| Proposed Fire Vehicle Access Plan | |
| Boundary House | |
| 30499 | |

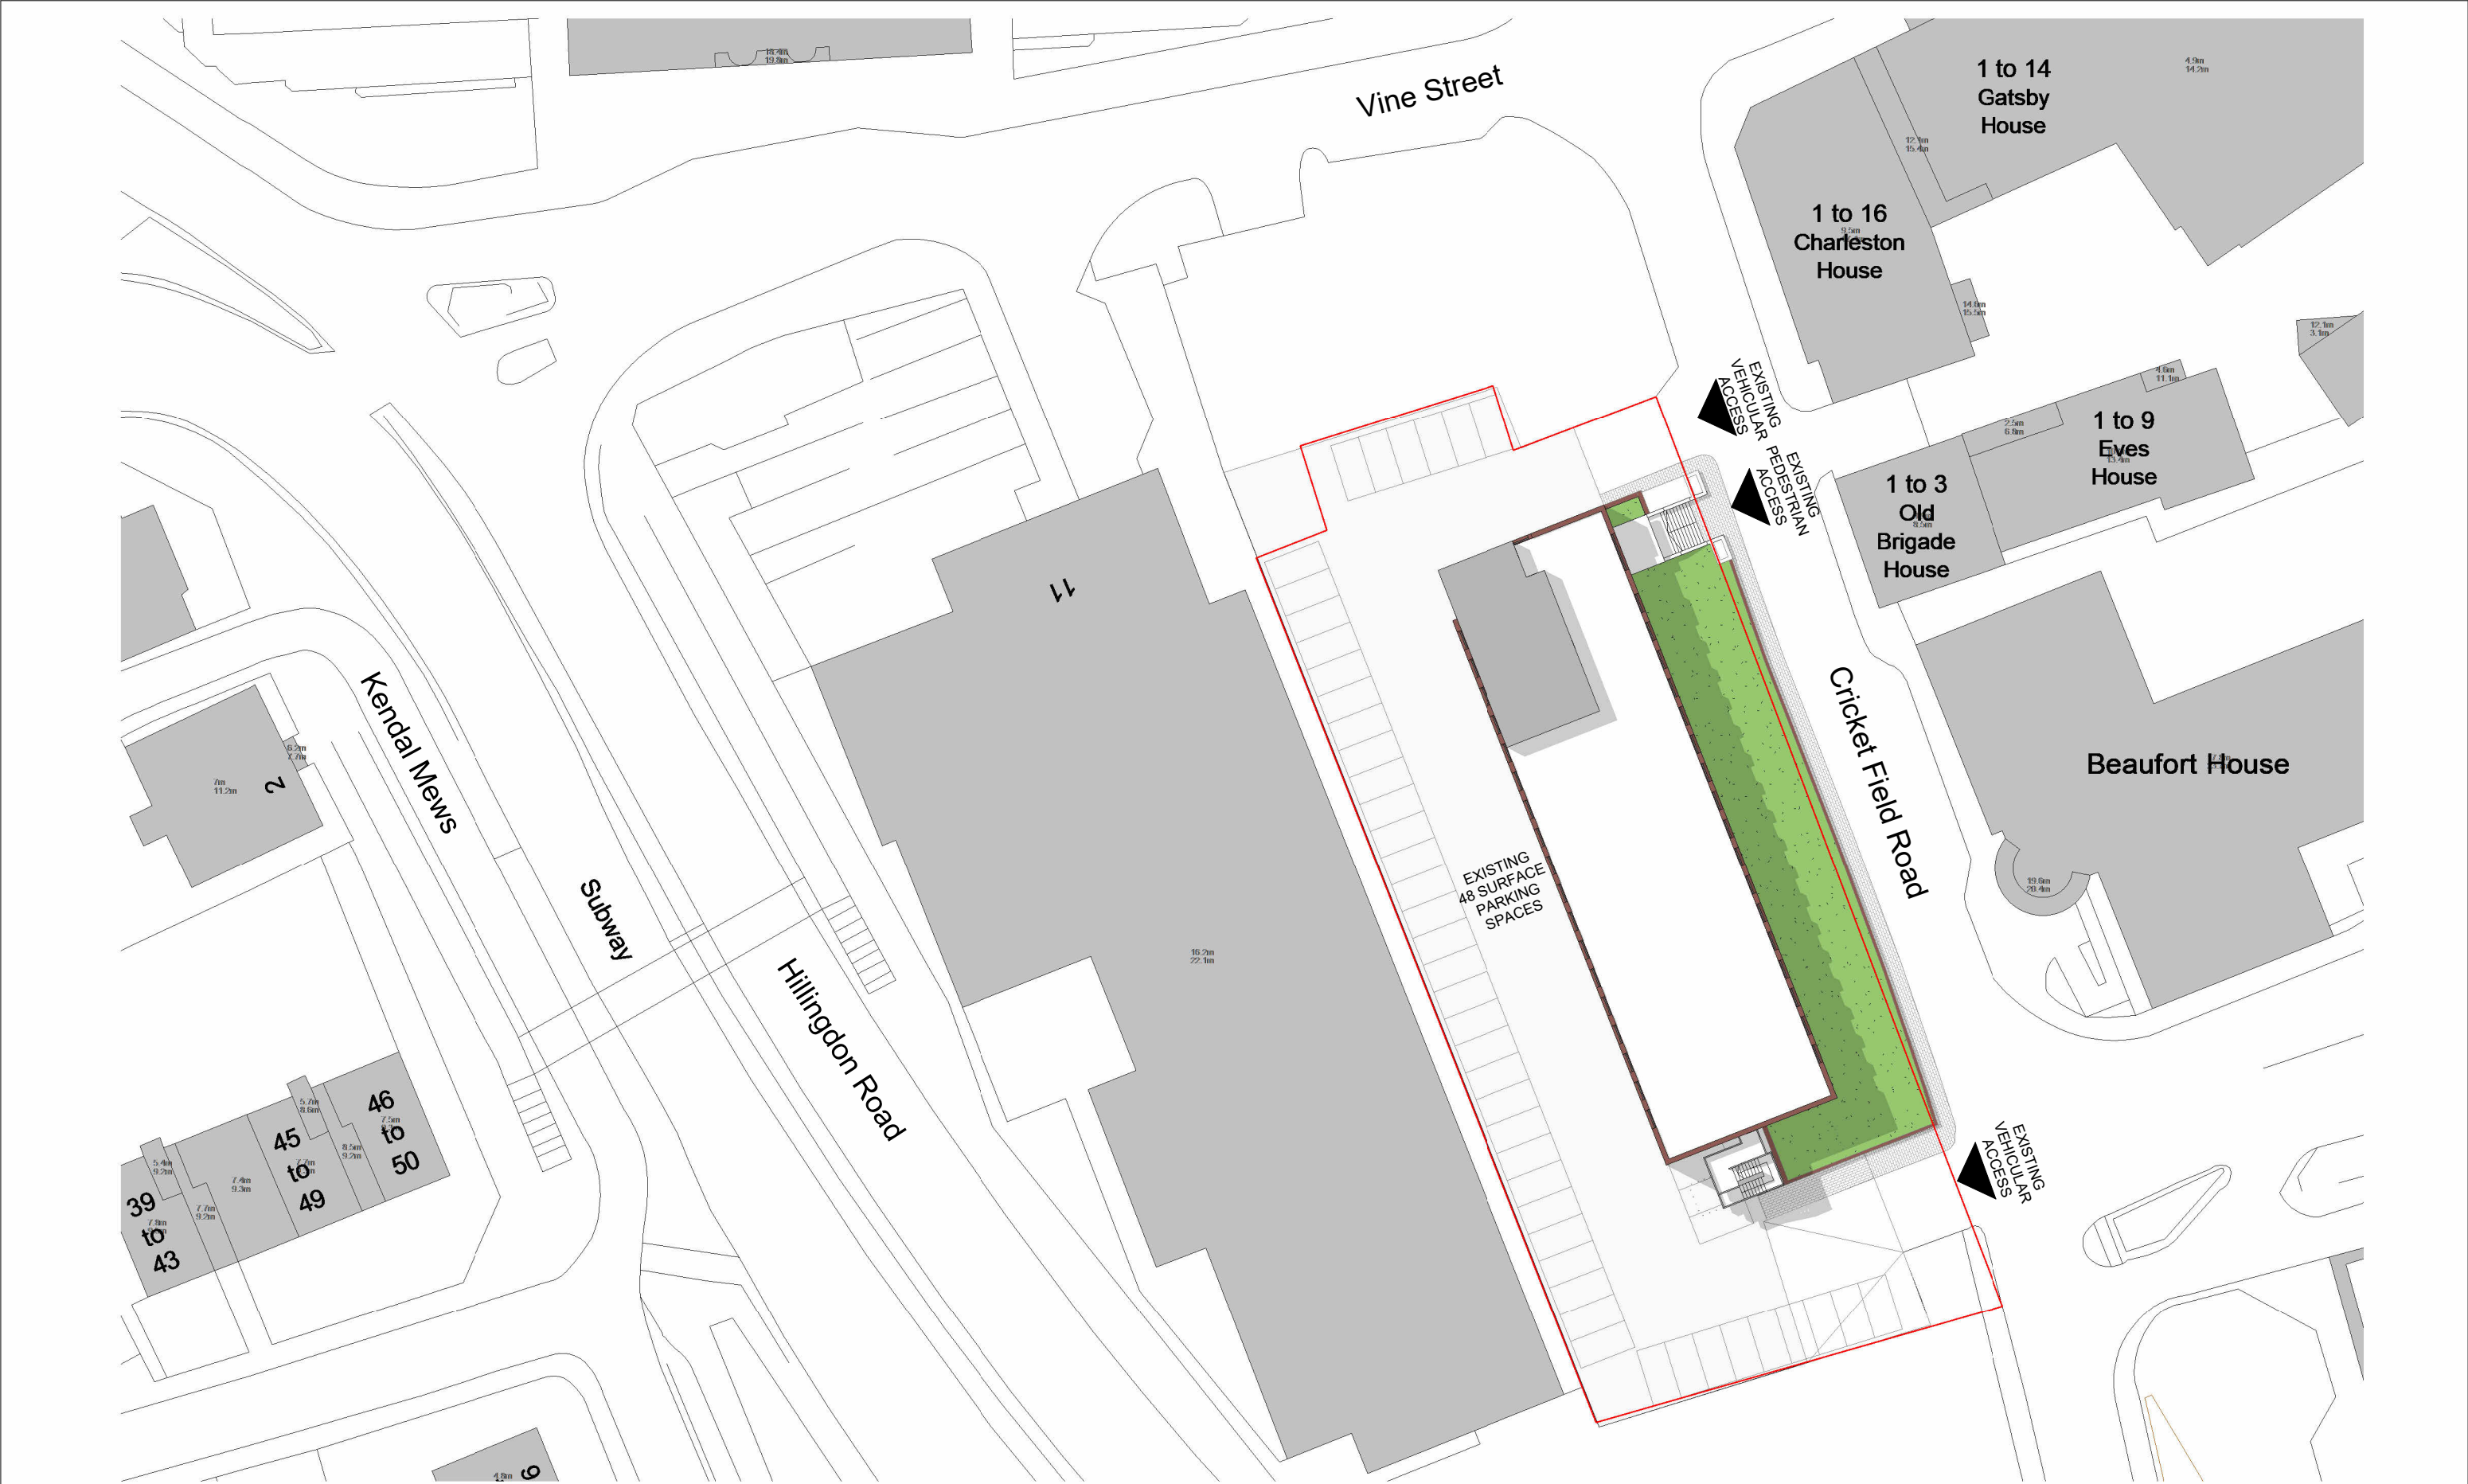
A fire tender accessible location is one which meets the following requirements:

1. The minimal width between kerbs on fire tender access roadways is to be less than 3.7m;
2. The minimal width of a fire tender accessible gateway is 3.1m;
3. The minimal clearance height is to be no less than 4m;
4. The minimum turning circles between kerbs is to be 26m and between walls is 29m;
5. The minimum carrying capacity should be no less than 17 tonnes

Where the length of a dead-end fire tender accessible roadway exceeds 20m, the route should be provided with turning facilities (i.e. a turning circle or hammerhead).

1. It is to be ensured that fire hydrants are provided within 90m of dry riser inlet points. Additional hydrants, if required are to be provided in accordance with BS 9990:2015
2. Buildings fitted with a dry fire main should have access for a fire appliance to within 18m of each fire main connection point, typically on the face of the building close to the entrance point leading to the fire-fighting shaft, with the inlet visible from the fire appliance.
3. Location of nearest fire hydrants need to be confirmed.

Drawing Title:
Proposed Basement Floor Plan
Planning Application

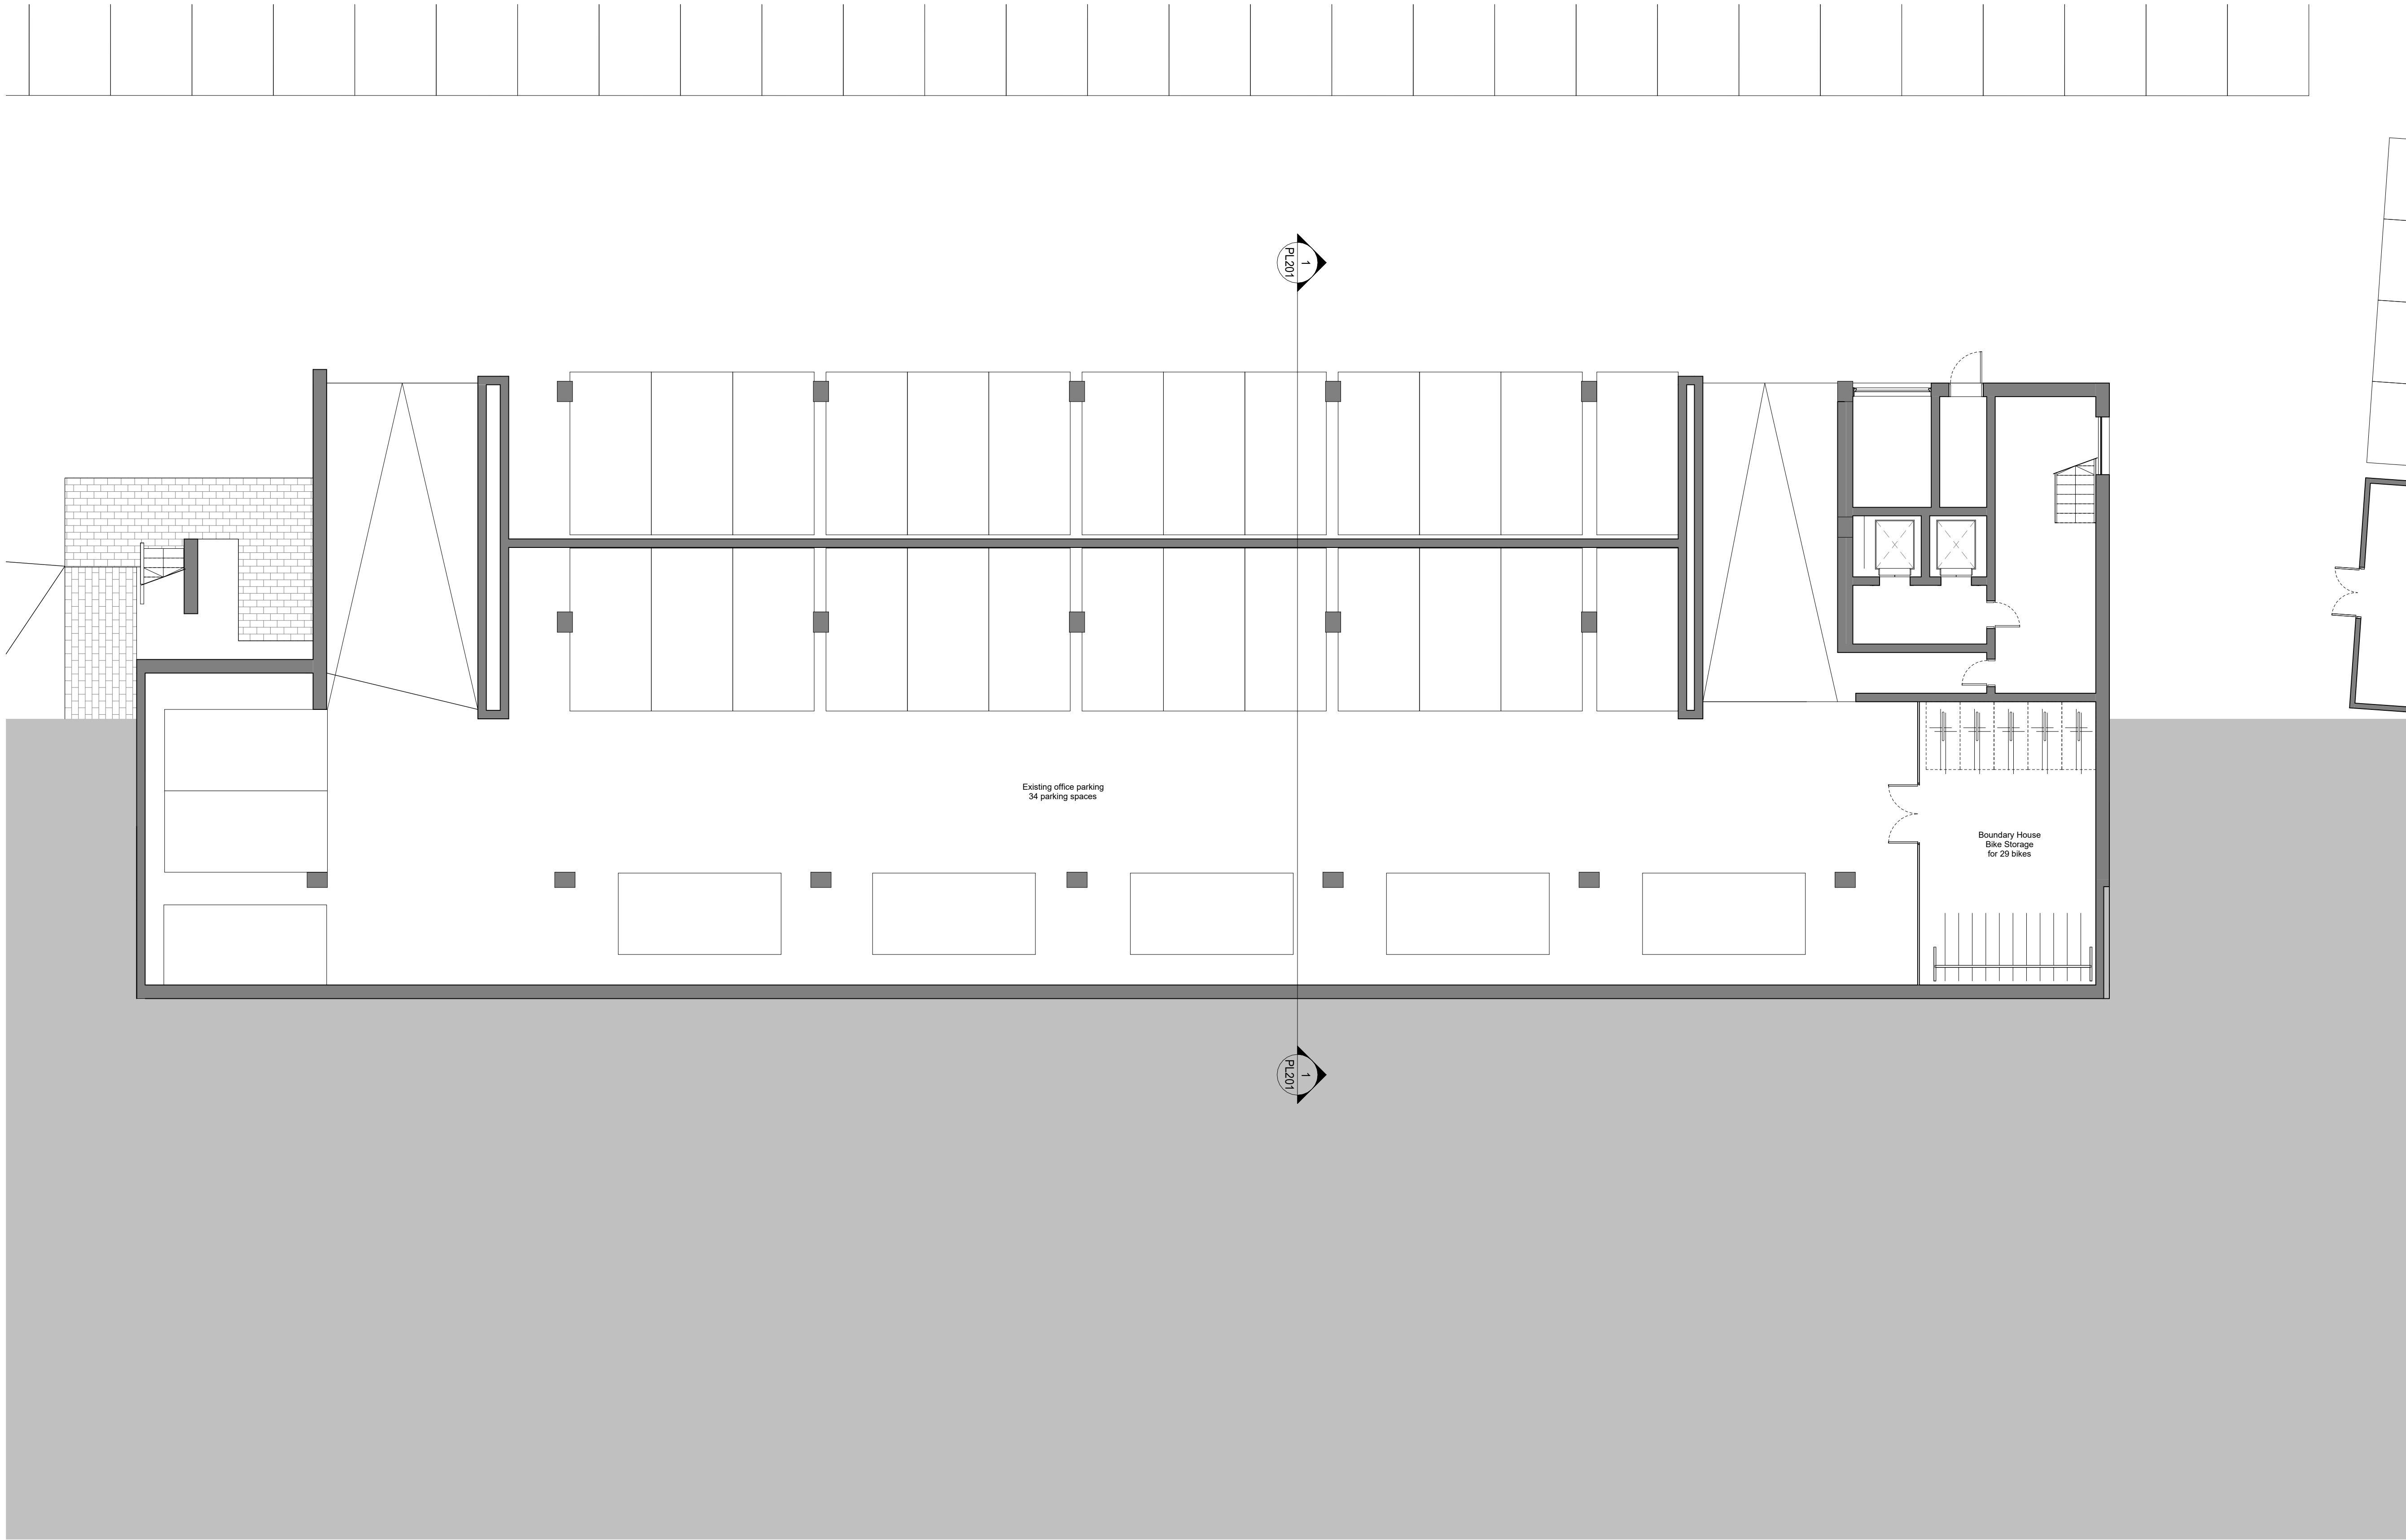
It is recommended to provide a location space for the pump room in the basement.

Basement should be provide with a sprinkler system as per BS EN 12845. (Clause 13, of BS 9991:2015.

Car park must be ventilated either through natural means or a mechanical ventilation system accordance with Clause 14.2.1.4 of BS 9991:2015.
